# Technical Memorandum

**Subject:** *989 Somerset Street Residential Development – Transportation Addendum No. 2, Rev. 1*

**Re: 989 Somerset Street**  
**TIA Addendum #2 – Response to City Comments**

**TIA Strategy Report – Parsons, Dated July 23, 2022**  
**TIA Addendum #2 – Parsons, Dated August 03, 2022**  
**Site Plan, Dated August 03, 2022 (within the Addendum #2)**

DRAWING TITLE:
 SITE PLAN

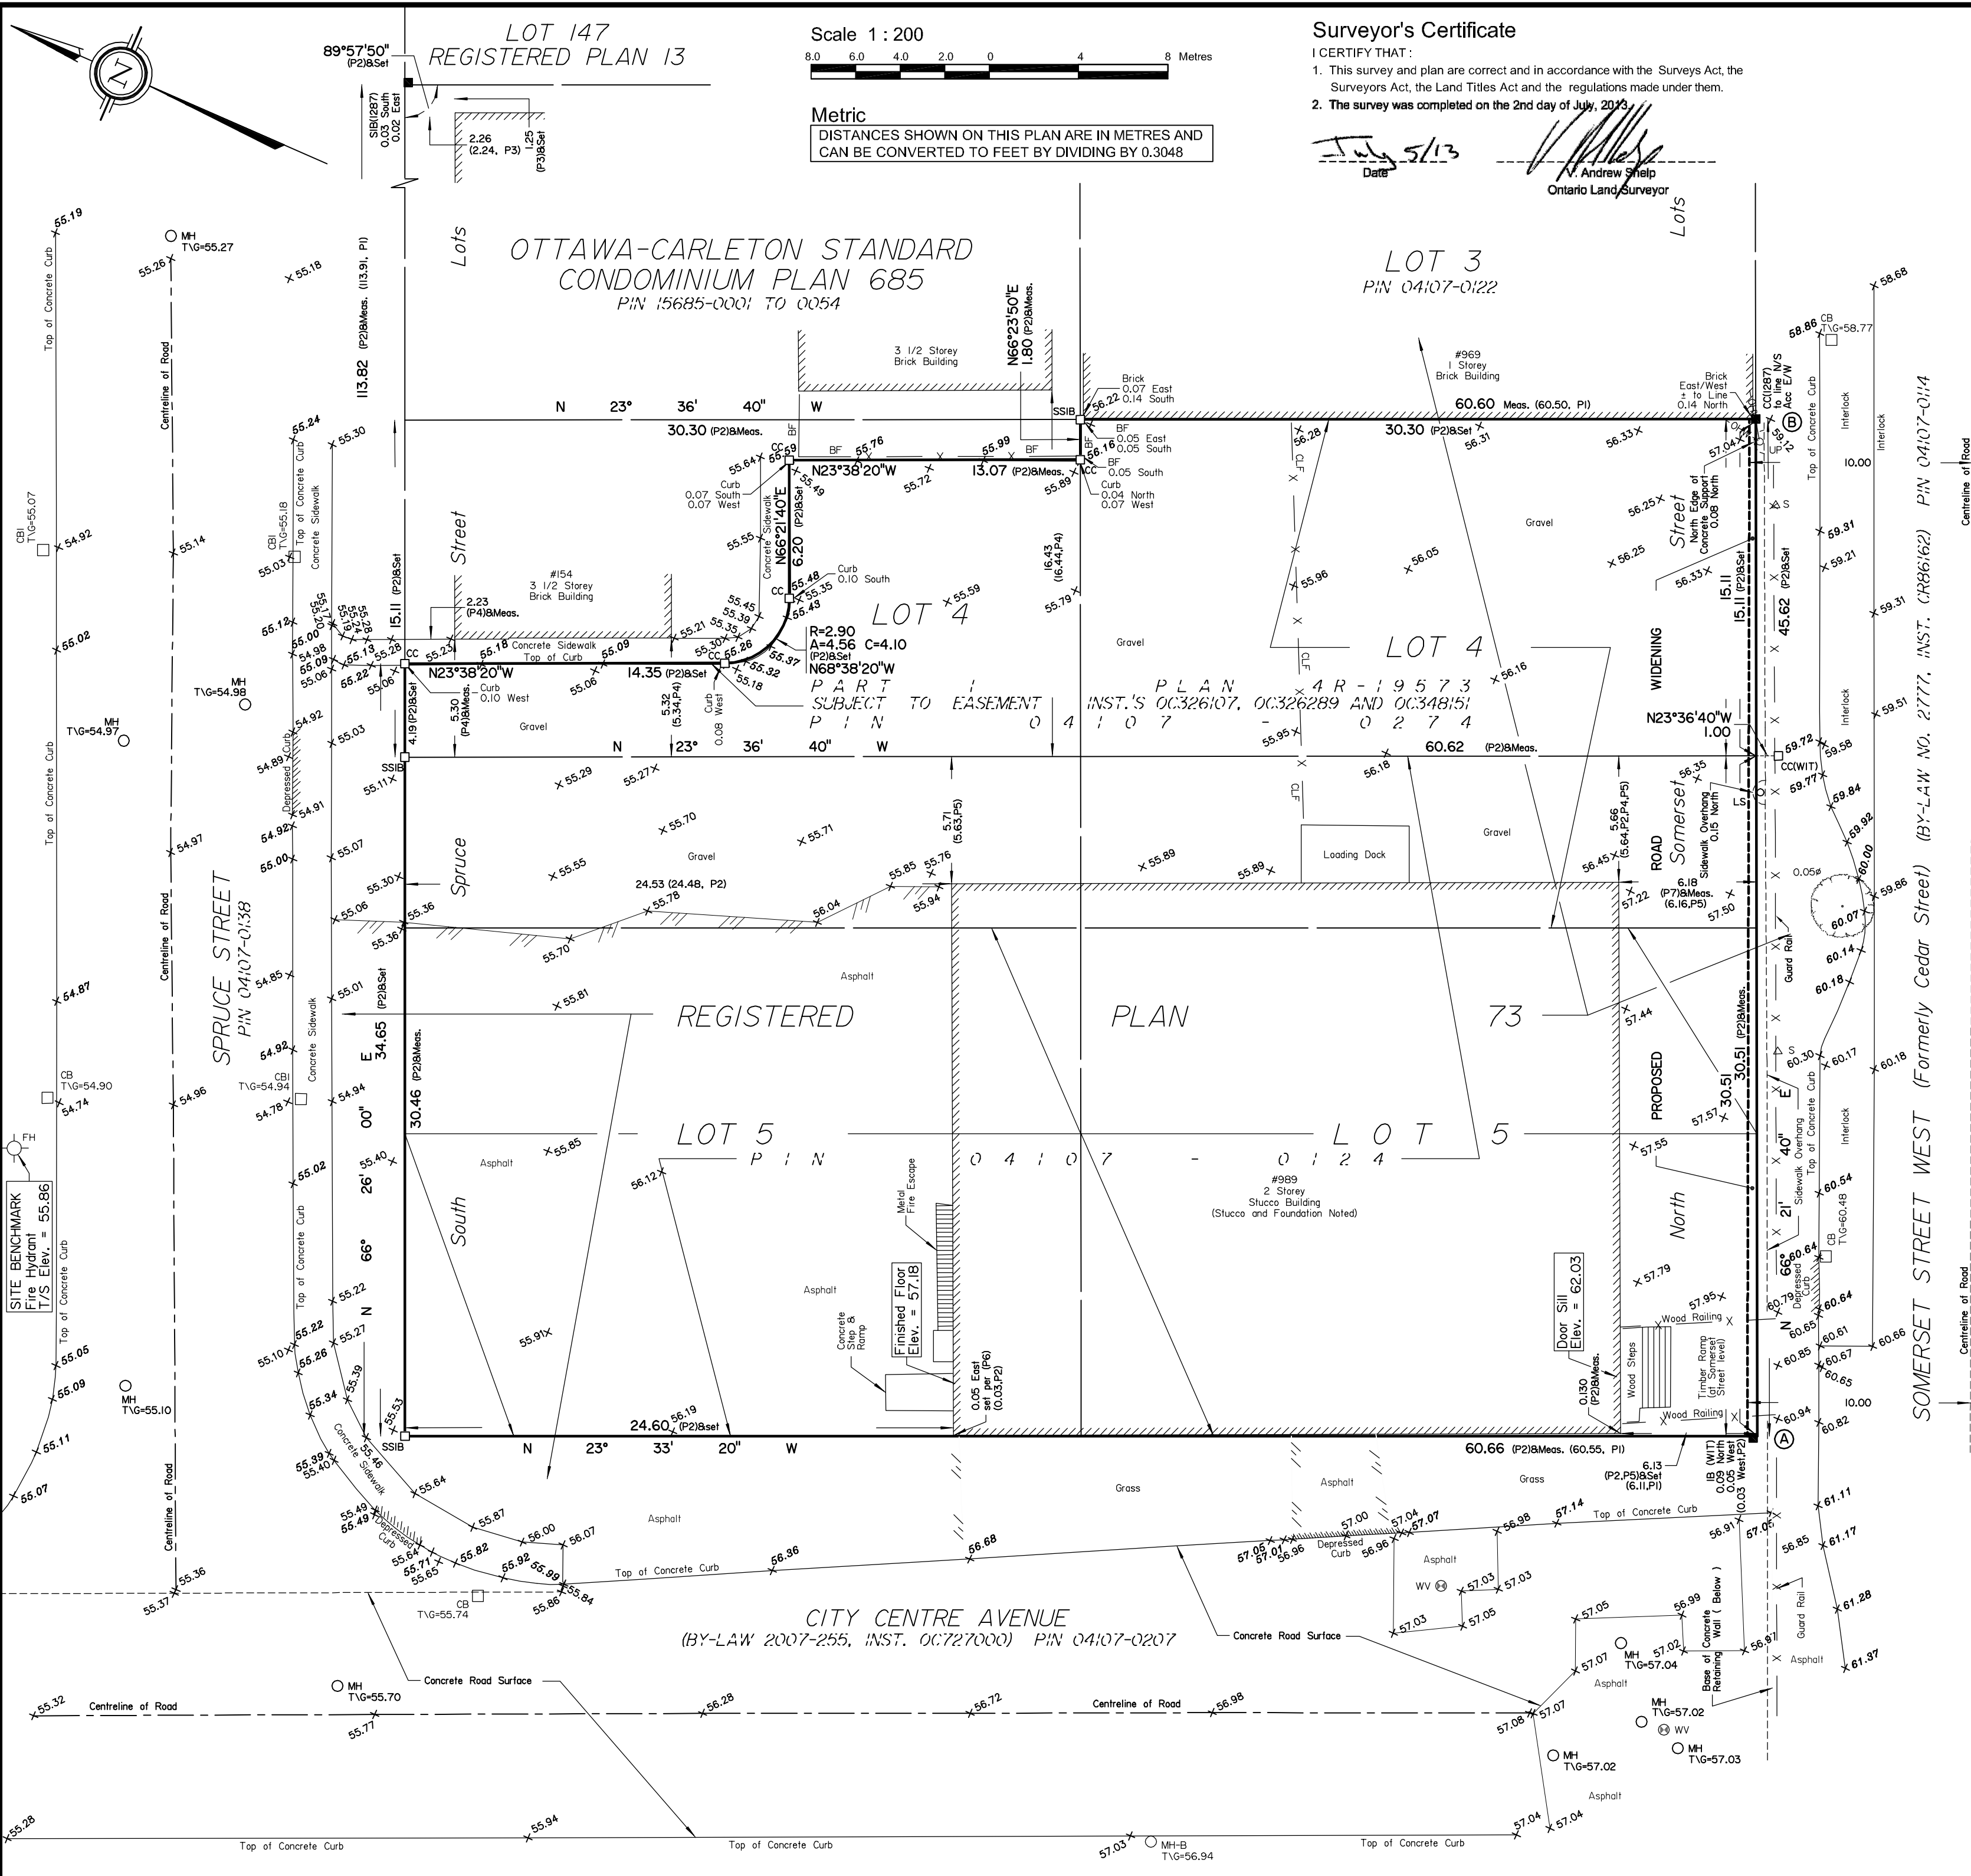
2. The site plan in Figure 1 lacks detail and is difficult to review. Please attach a detailed copy of the latest site plan to the Addendum for review. The site servicing and grading plan would also be helpful.  
New Site Plan as well as site servicing and grading plans provided as an attachment.

3. Figure 1 does not show a continuous concrete sidewalk on the south side of Spruce Street across the new access. Confirm new access will be constructed per City of Ottawa standard detail SC7.1. An attached site servicing and grading plan would help alleviate concerns.  
New Site Plan provided.

5. Provide more detail on the public stairs being provided between Somerset Street and City Centre Avenue (as indicated by Figure 1). These stairs were not discussed in the 2019 TIA Strategy. Ensure the stairs meet all requirements of the Section 2.3 of the City of Ottawa Accessibility Design Standard, including the provision of TWSIs per Section 2.3.1.3. The stairs are located outside, and are entirely inset into the building with the upper floors directly above the stairs. They are 100% located on private property. The rendering below illustrates its location (see bright red entrance to stairs at Somerset level). The stairs will be constructed according to the City of Ottawa Accessibility Design Standards, including TWSI installations.

6. Please discuss the location of the increased number of bicycle parking stalls, and how residents will access the bicycle parking area.  
Hobin Architecture has provided the following description of the bicycle parking stall location:  
*“The bicycle stalls for 989 Somerset are located within the building on the ground level and at parking levels P1, P2, and P3 within designed storage rooms. The parking stalls located on the ground level have direct access to the exterior via a door leading to City Centre Avenue. Additionally, residents using these bicycles stalls may access the*

11. The segment MMLOS form indicates that sidewalk width on Spruce Street and City Centre Avenue (east side) is  $\geq 2$  m. However, previous site plans and site grading plans have shown 1.8m sidewalks in these locations. Please confirm sidewalk along the site frontage will be upgraded to a width of at least 2.0 m.  
*The proponent will provide 2-meter sidewalks for Spruce Street (south side) and City Centre Avenue (east side) adjacent to the site. This has been demonstrated on the site plan (See Appendix A)*

*exterior via a corridor and vestibule leading to a surface parking lot accessed by Spruce Street. The corridor also connects these residents to the amenity/lounge space at grade, and therefore the elevator core. Residents may use the elevator to reach level 2 where they can access Somerset Street West.*

*The bicycle parking stalls located within the parking garage levels are accessible via elevator. Users are able to reach ground level and access either City Centre Avenue via a corridor and vestibule, or Spruce Street, via the surface parking lot, or, reach level two, and access Somerset Street West.*

*Cyclists accessing the building at level two on Somerset Street West may use the elevator to access ground level or the parking levels to store their bicycle.”*

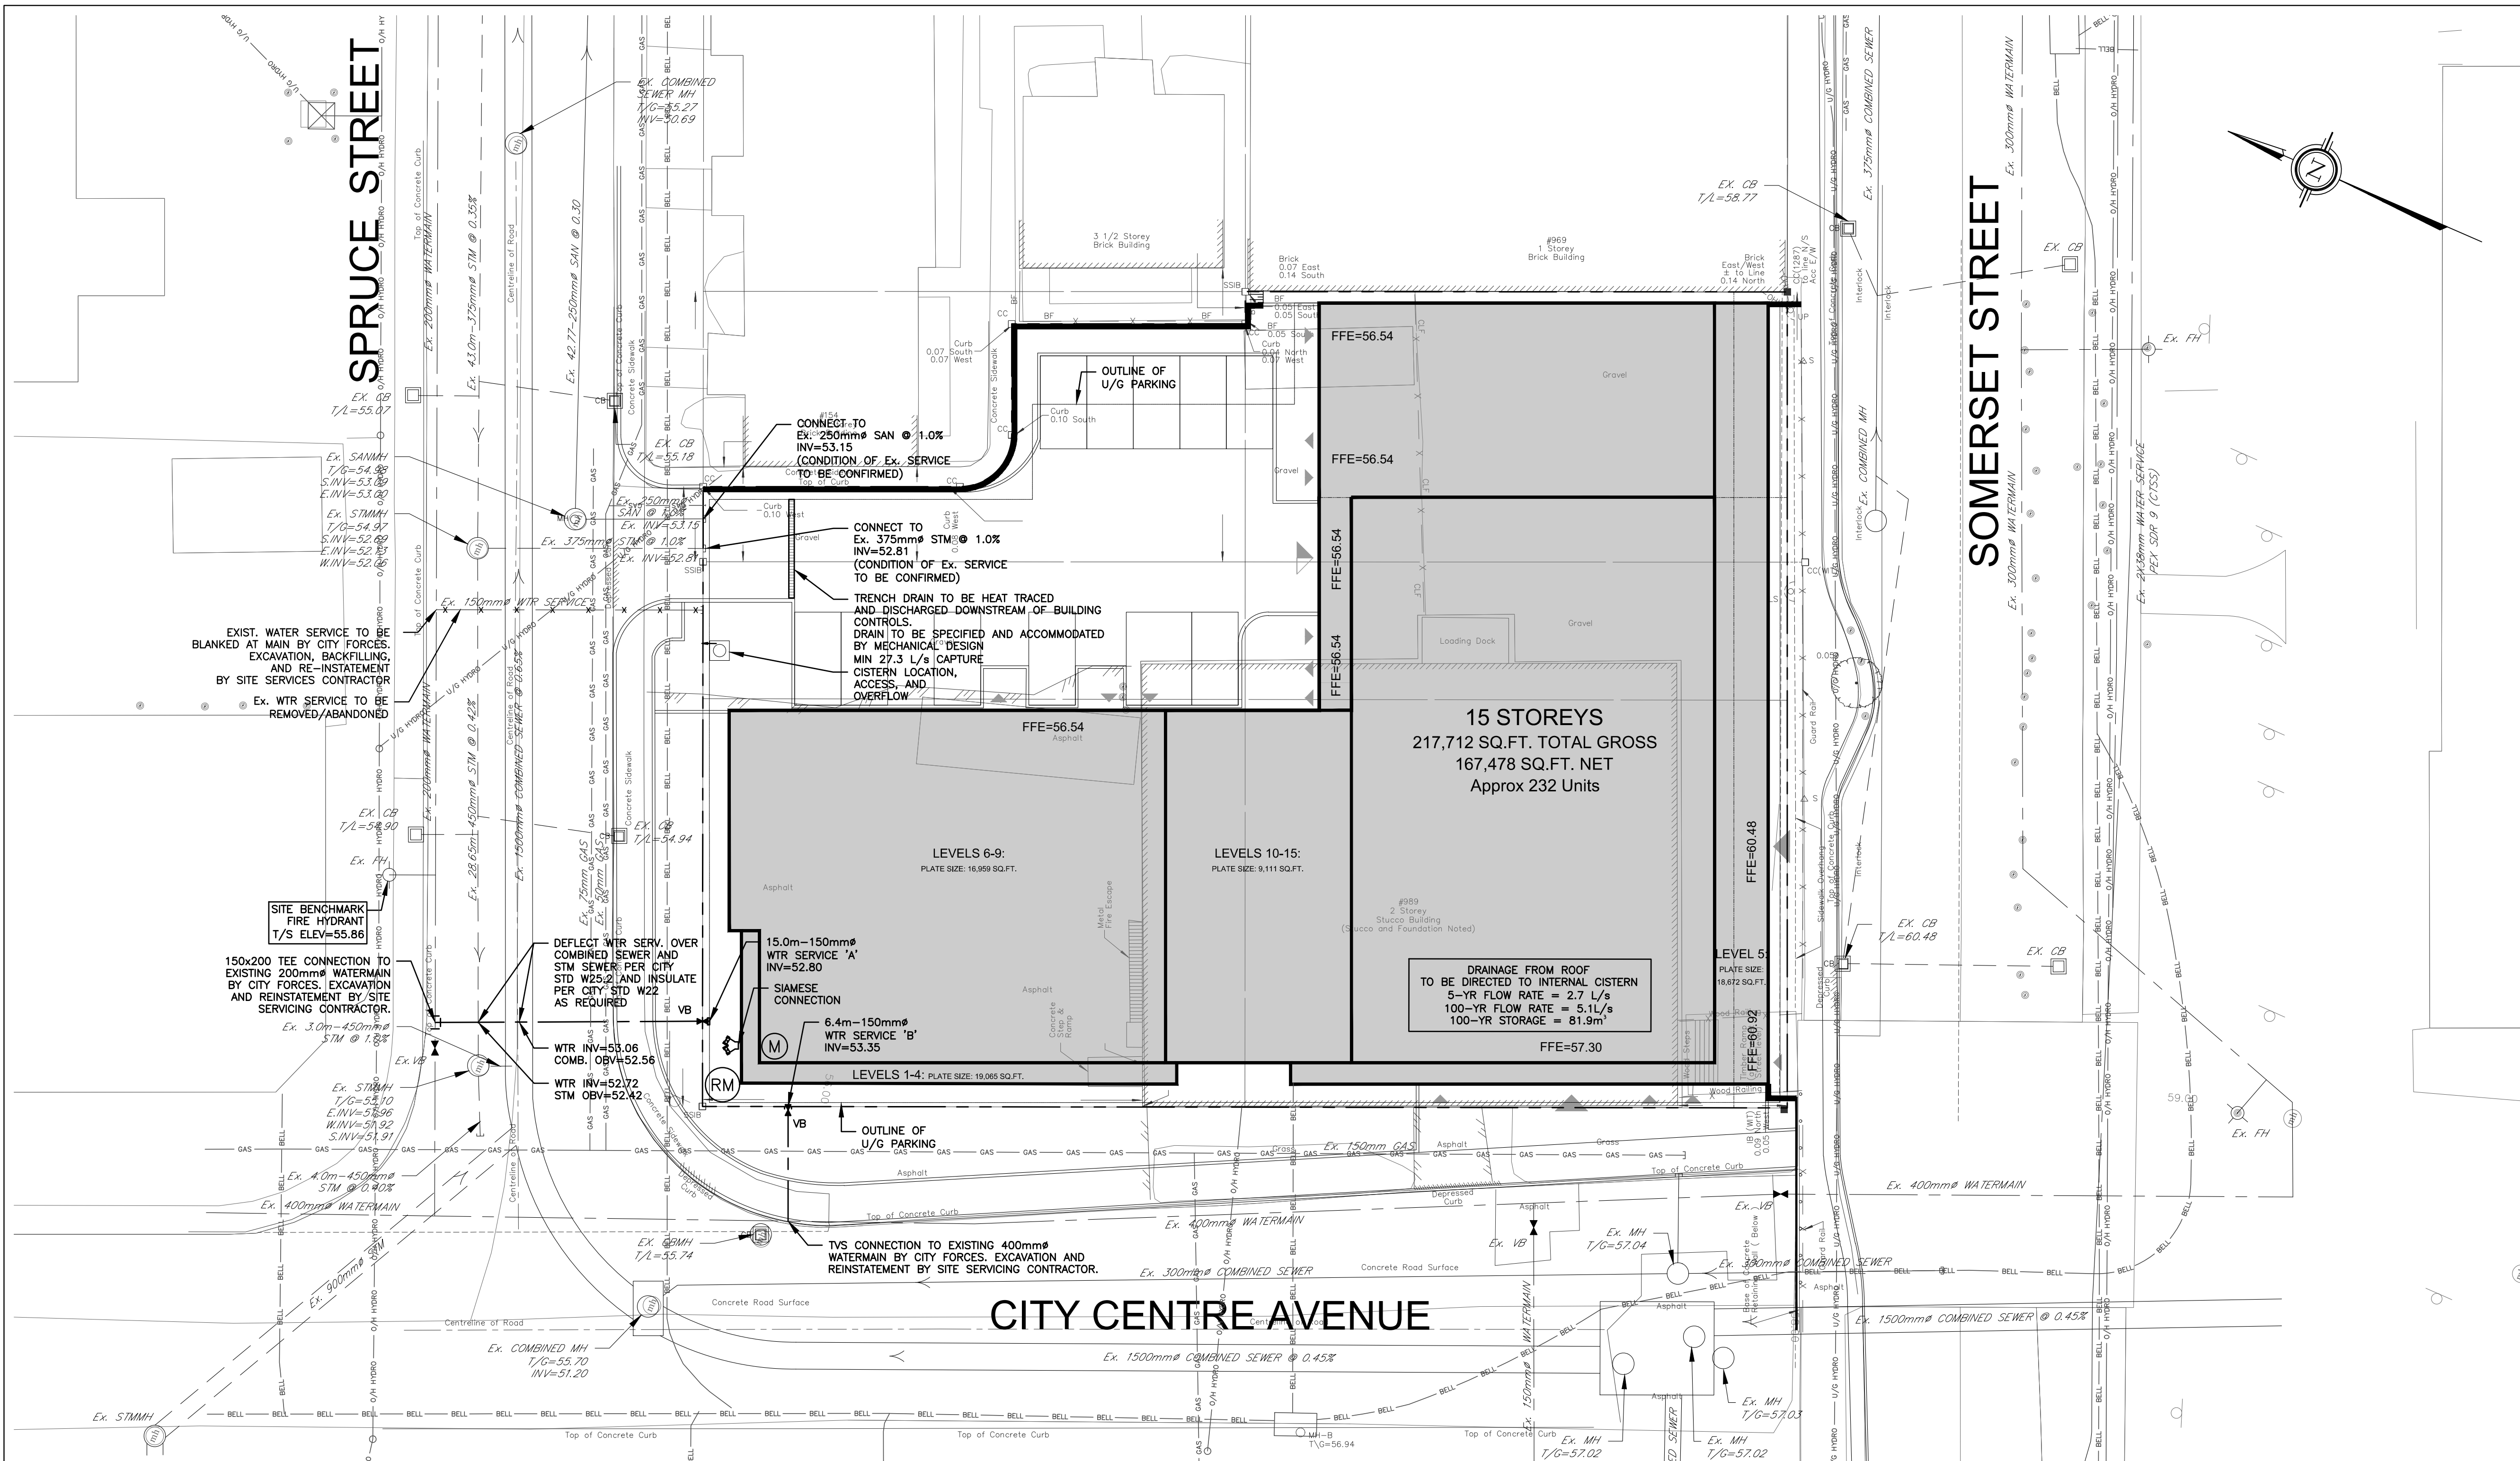
4. Please provide site access grades and ensure compliance with Section 25 (1) (s) and 25 (1) (u) of the Private Approach By-Law. An attached site servicing and grading plan would help alleviate concerns.  
The grading plan indicates that the private approach serving the parking area does not exceed 2% near to the roadway, adhering to Section 25 (1) (s).  
The grading plan also indicates that a 3.5% slope begins approximately 9.8m away from the highway line, which is compliant with Section 25 1 (u).  
Site Servicing and grading plan have been provided as an attachment (Appendix A).
